**WELWYN HATFIELD BOROUGH COUNCIL  
DIRECTORATE OF STRATEGY AND DEVELOPMENT**

**DELEGATED APPLICATION**

**Application No:** 6/2016/2098/FULL  
**Location:** Warrenwood Manor, Hornbeam Lane Brookmans Park Hatfield  
 AL9 6JF  
**Proposal:** Change of use of land to residential and retention of maintenance and storage outbuildings associated with the maintenance and upkeep of the estate and grounds of Warrenwood Manor  
**Officer:** Mrs S Smith

**Recommendation:** Refused

Maintenance & Groundsmans Store
 Elevations as Constructed : Sheet 1

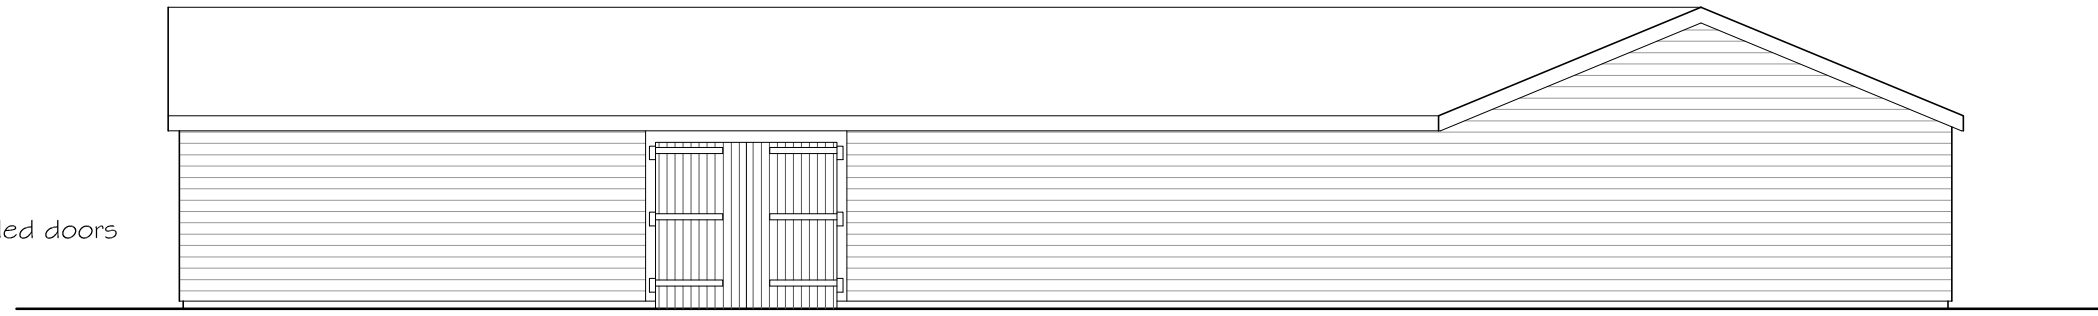
Whilst officers appreciate that the wider Warrenwood Manor site is extensive, and there is a need for the storage of equipment associated with the maintenance of the land, the size of the proposed building is excessive including two workshops, a tractor and trailer store, two plant and equipment stores, a storage area and animal feed area, seasoned log store and log cutting and drying area.

The size of the building is large. The amount of areas within it would appear to be excessively large for the justification provided by JSP Management Ltd with no robust justification provided justifying the size of this building and clarifying exactly the amount of space required for all the machinery and tools. Additionally no mention has been provided outlining why two workshops and

mess room are required together with the animal feed. Furthermore, the building also includes areas for log cutting and drying and a seasoned log store, which are excessively large and could reasonably be stored within the garage/basement attached to the dwelling.
